Reviewed by  
dsdgrimm  
03/28/2019 12:27 PM

# PRELIMINARY AND FINAL DRAINAGE PLAN AND REPORT

## POENITSCH SUBDIVISION

Add PCD File  
No. MS193

DRAINAGE PLAN
POENITSCH SUBDIVISION

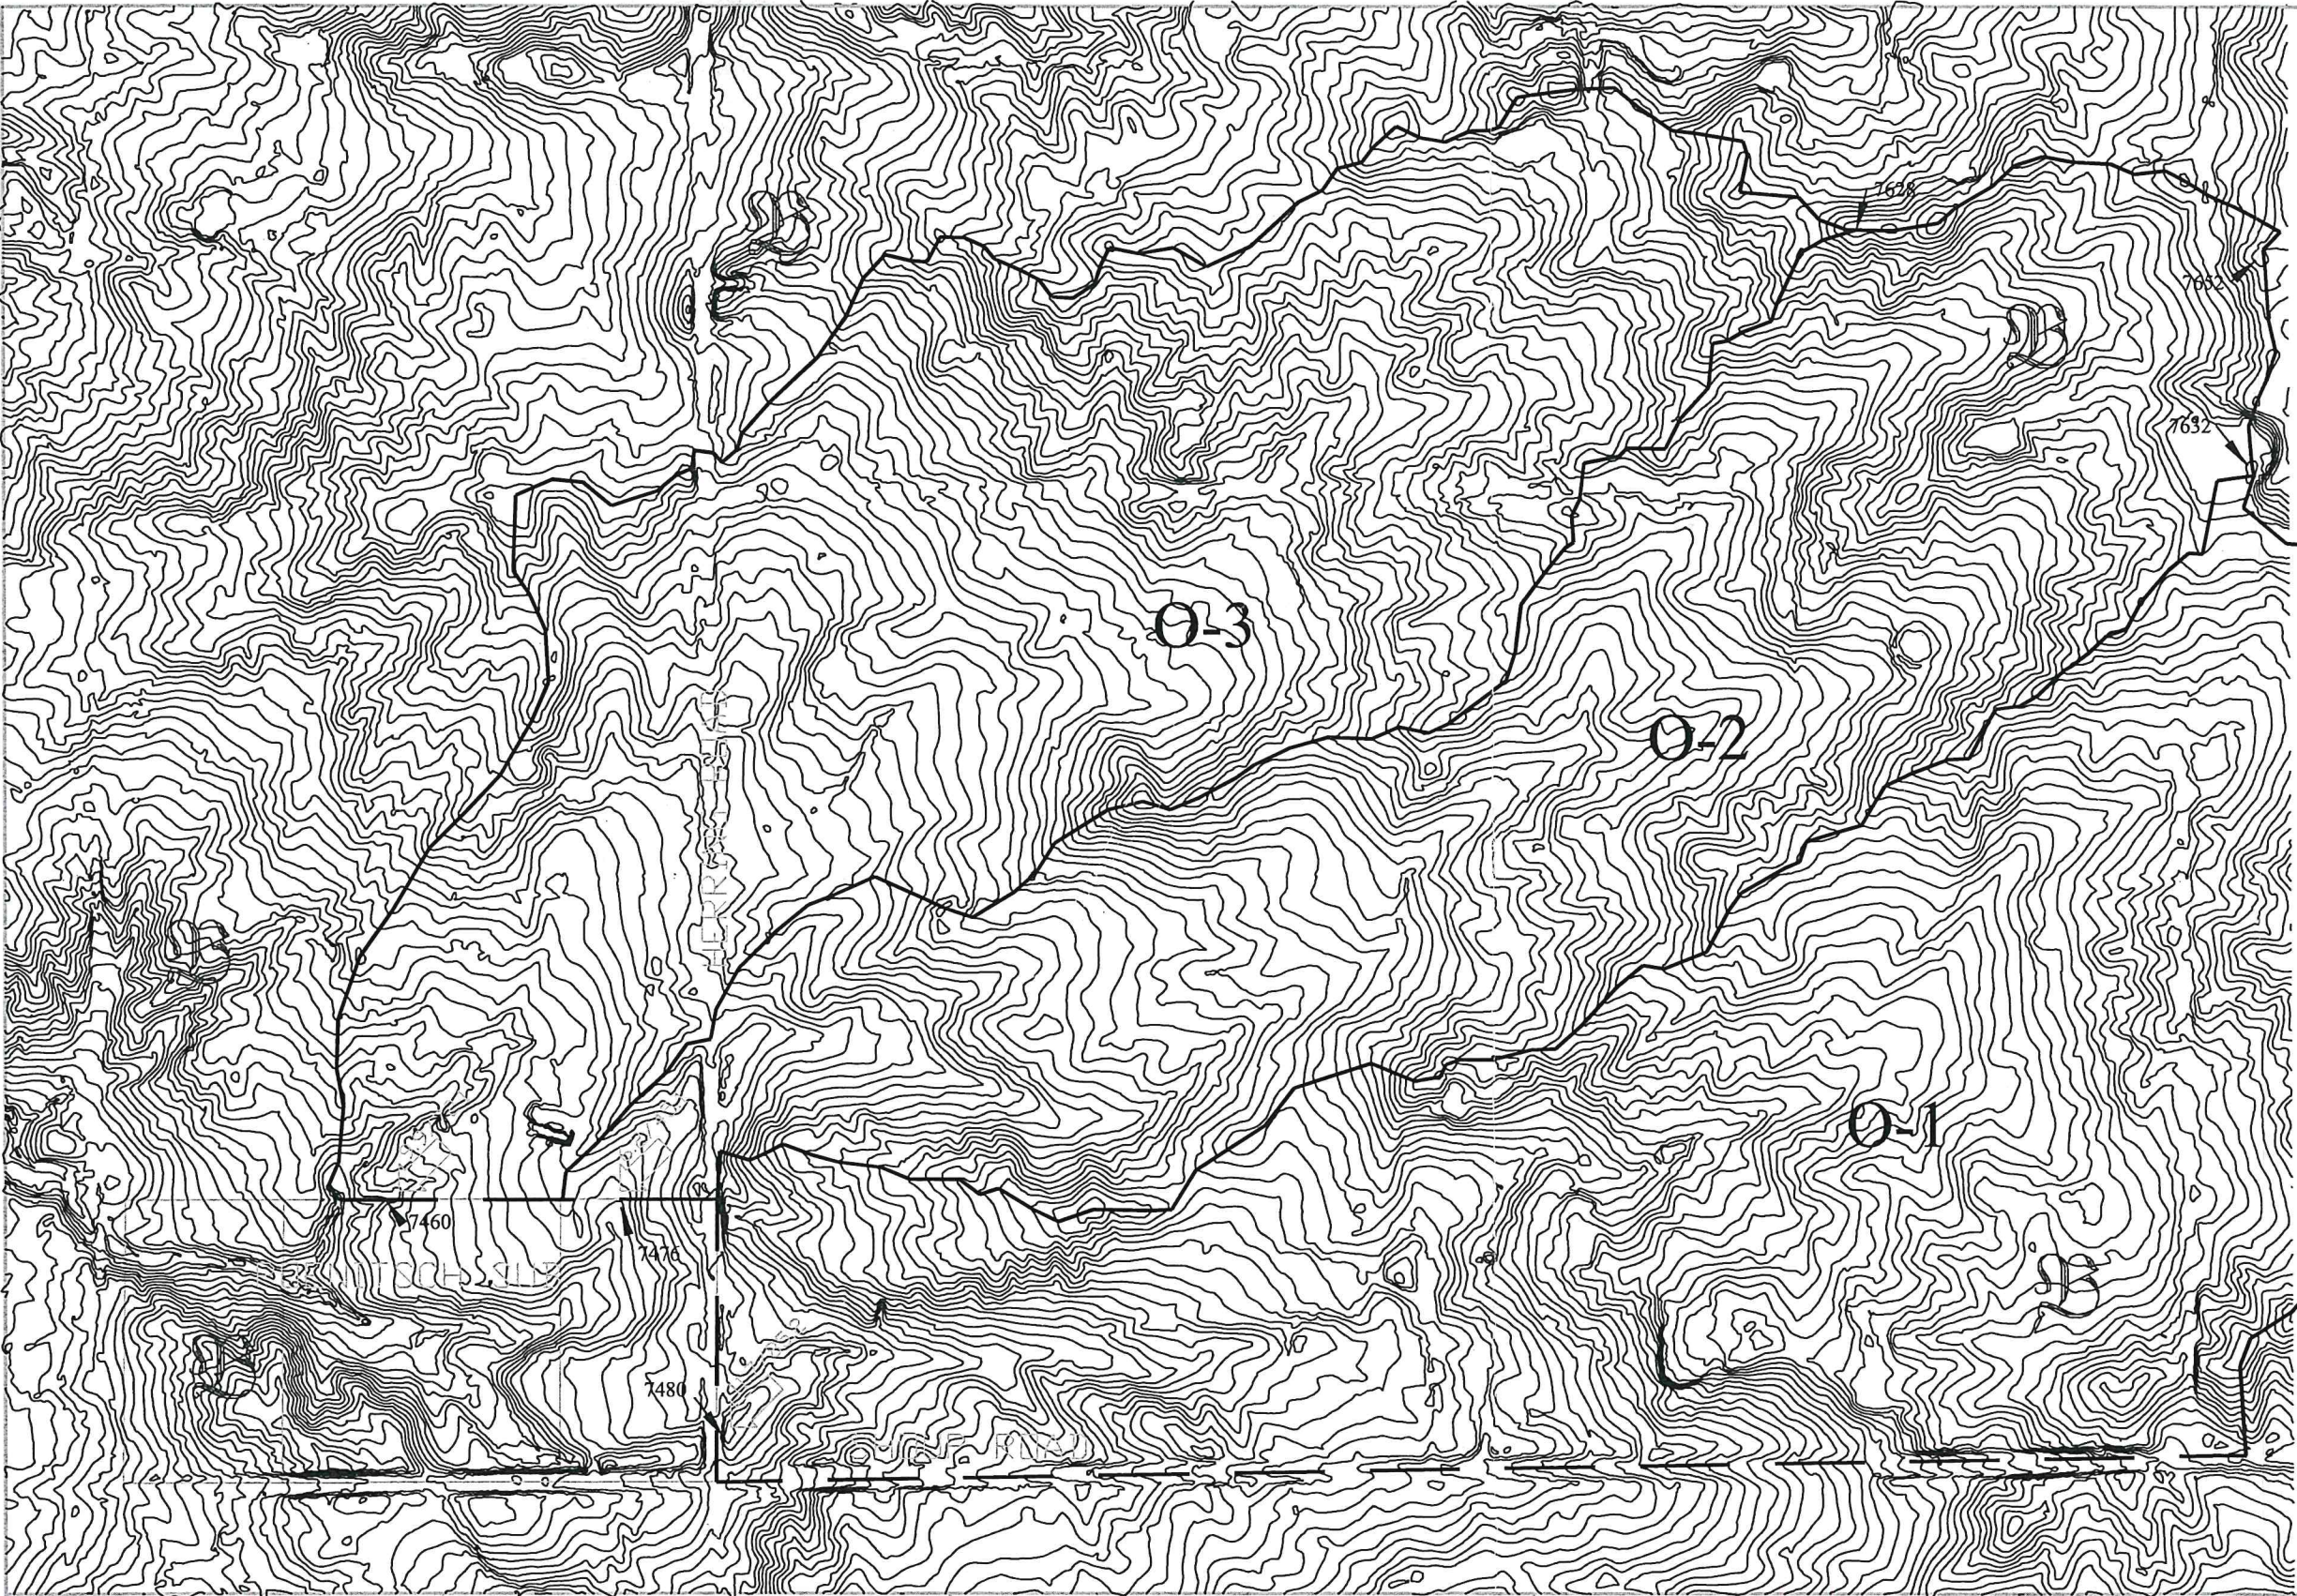
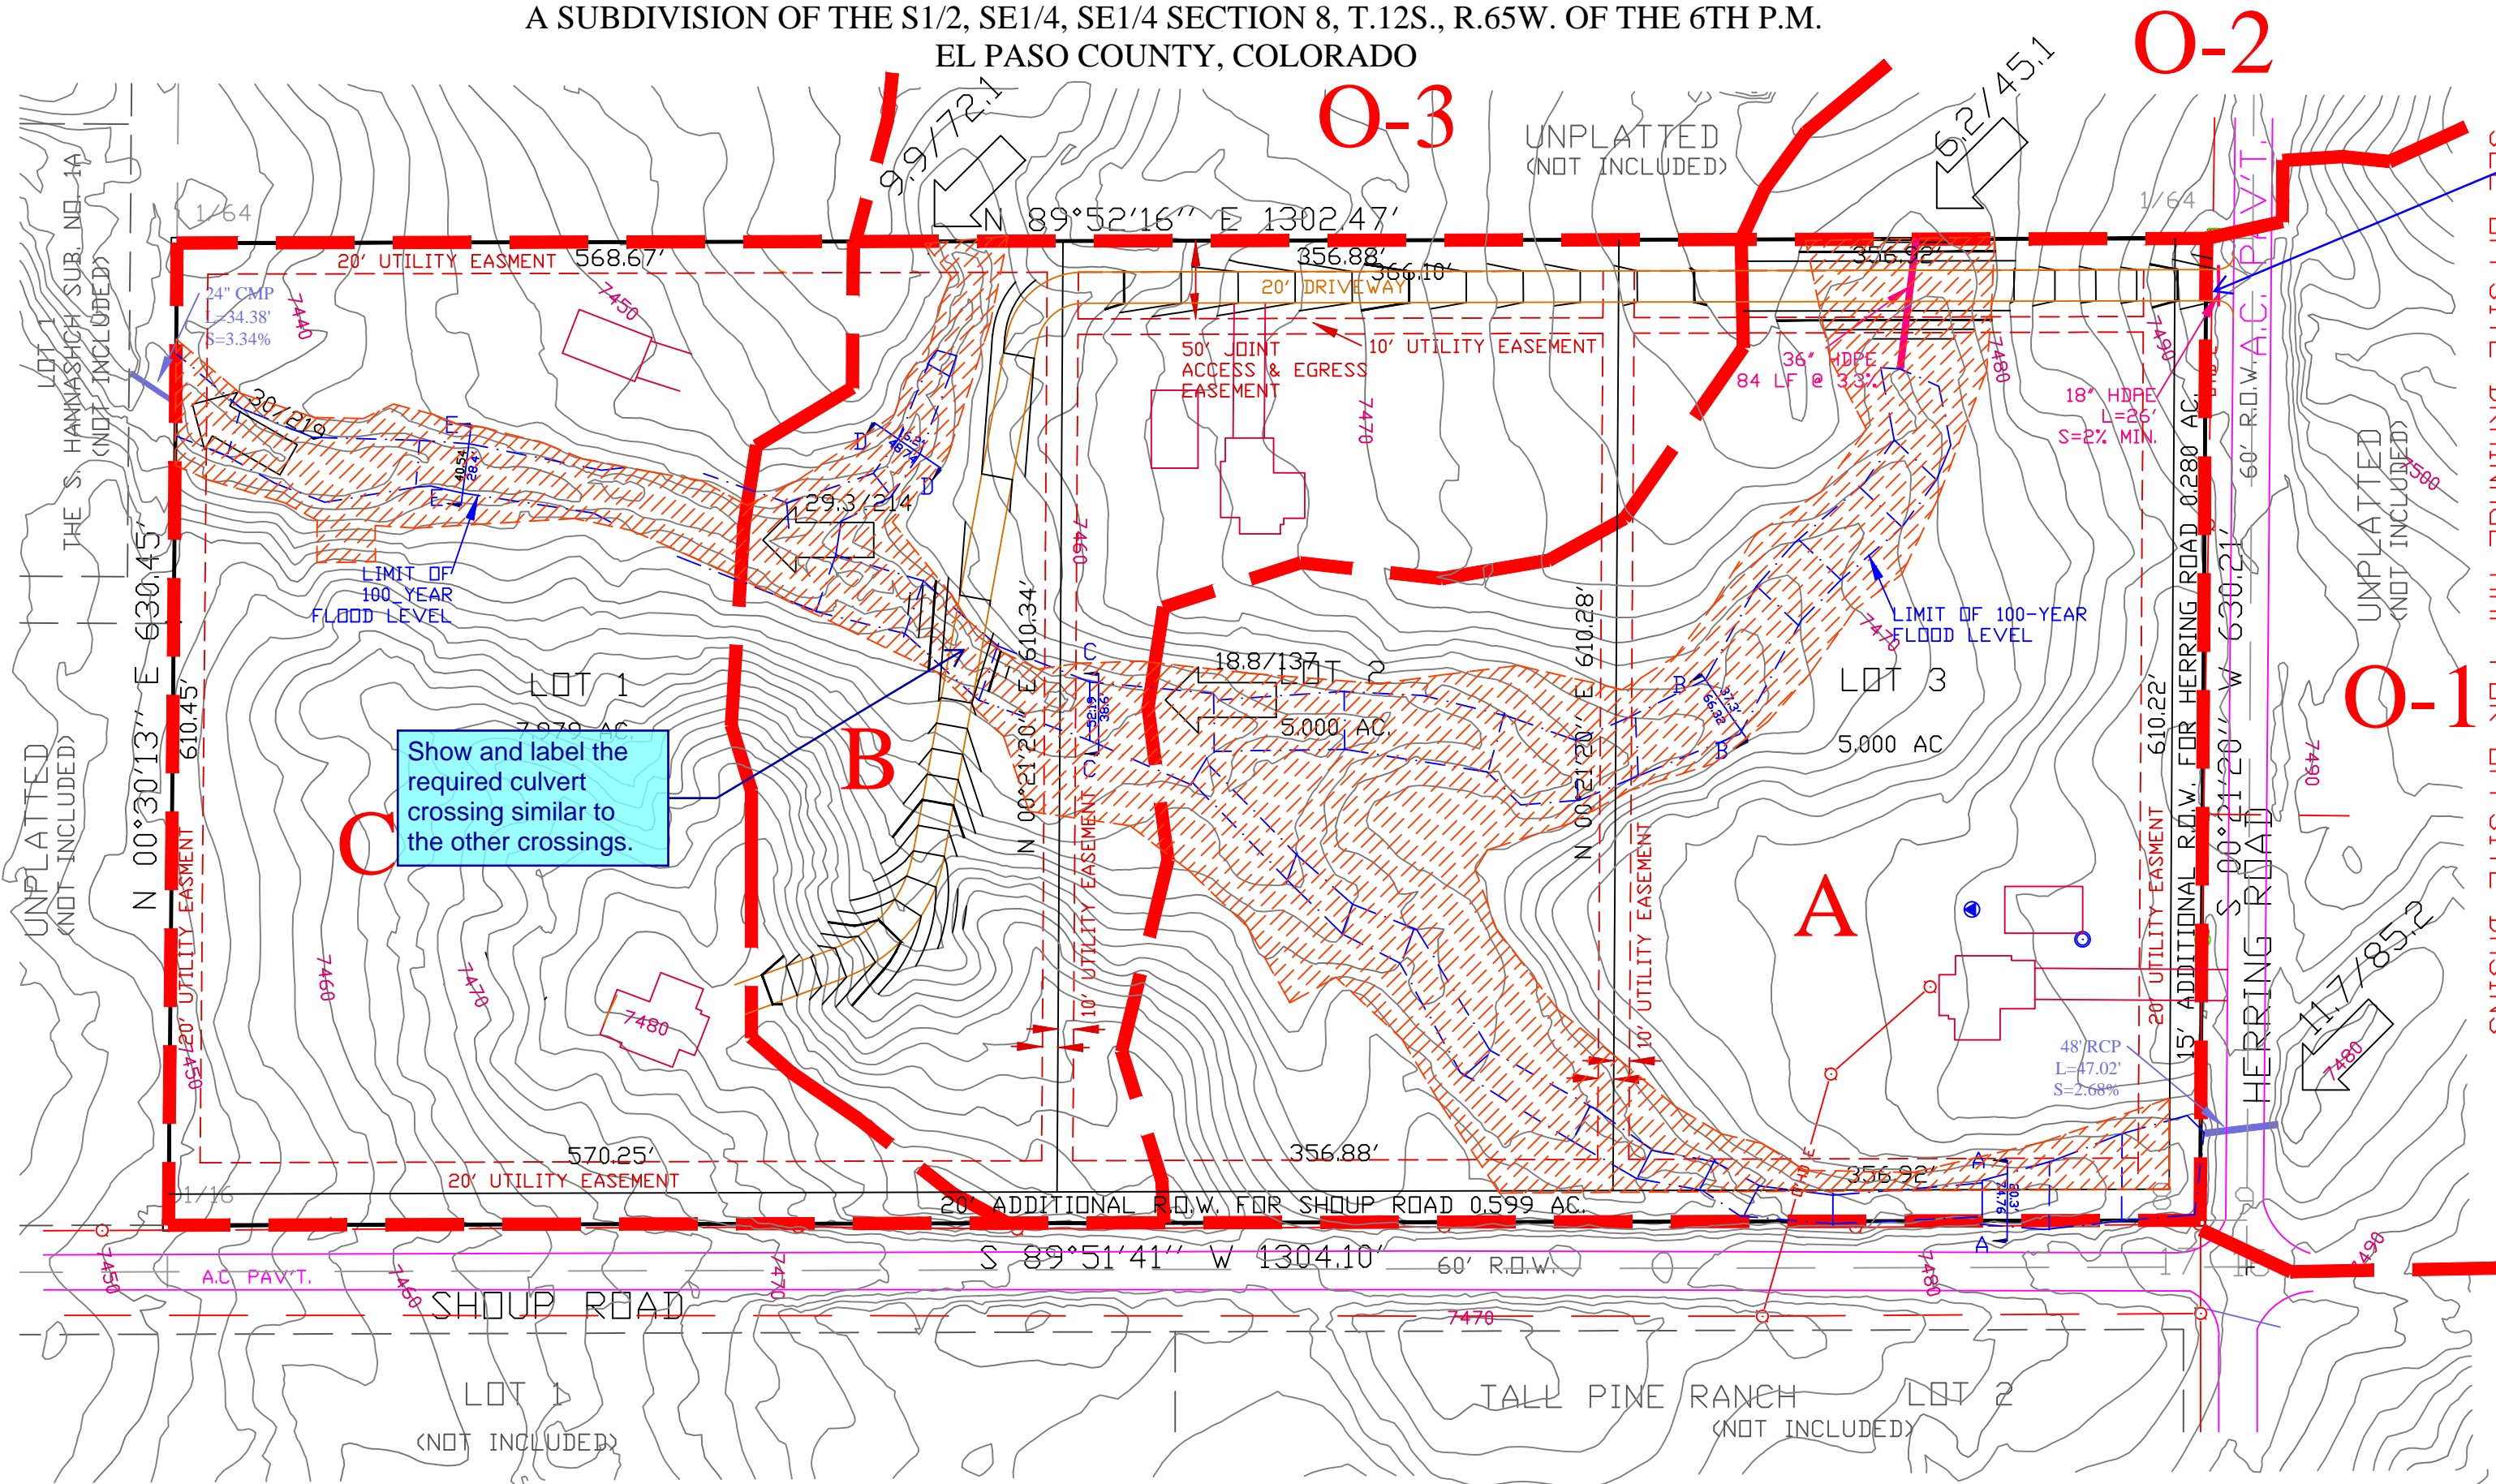
It appears that the drainage map shows only 26' of 18" HDPE pipe. Please clarify.
